REQUEST

Current Zoning: MUDD-O (Mixed Use Development District, Optional)
Proposed Zoning: MUDD-O SPA (Mixed Use Development District, Optional, Site Plan Amendment)

SUMMARY OF PETITION

The petition proposes to increase the number of residential units from 450 units to 550 units.

SHEET NUMBER  
**RZ-1**

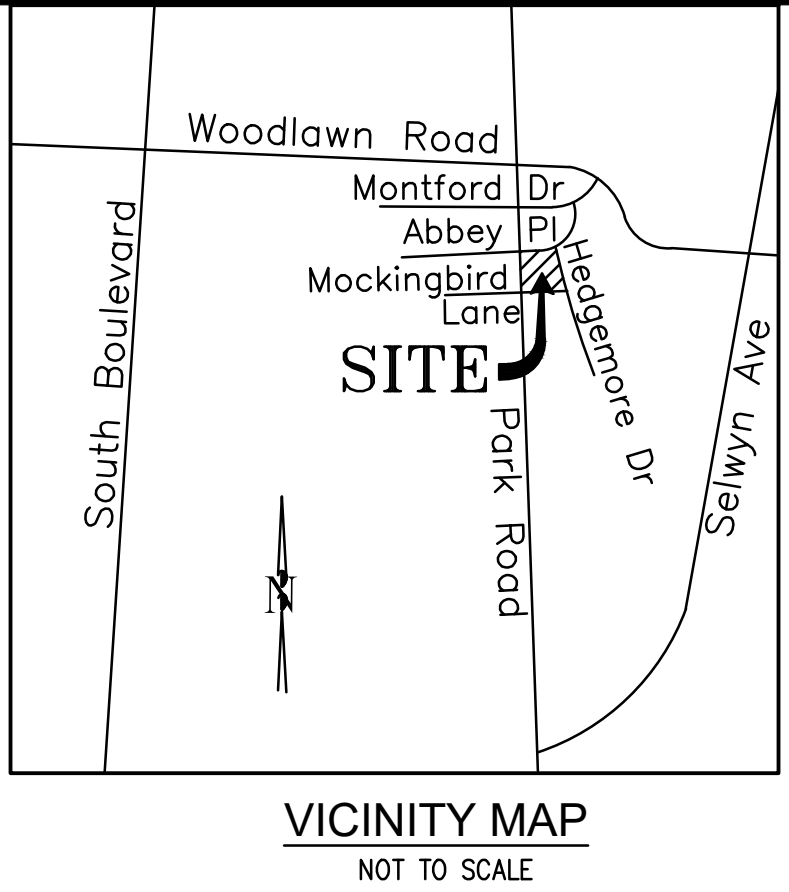
1. ~~Site plan needs to show dimension of future back of curb from centerline.~~ [Addressed](#)

2. ~~Tree survey required. Missing street trees along Hedgemore Drive, Mockingbird Lane, and Abbey Place.~~ [Addressed](#)
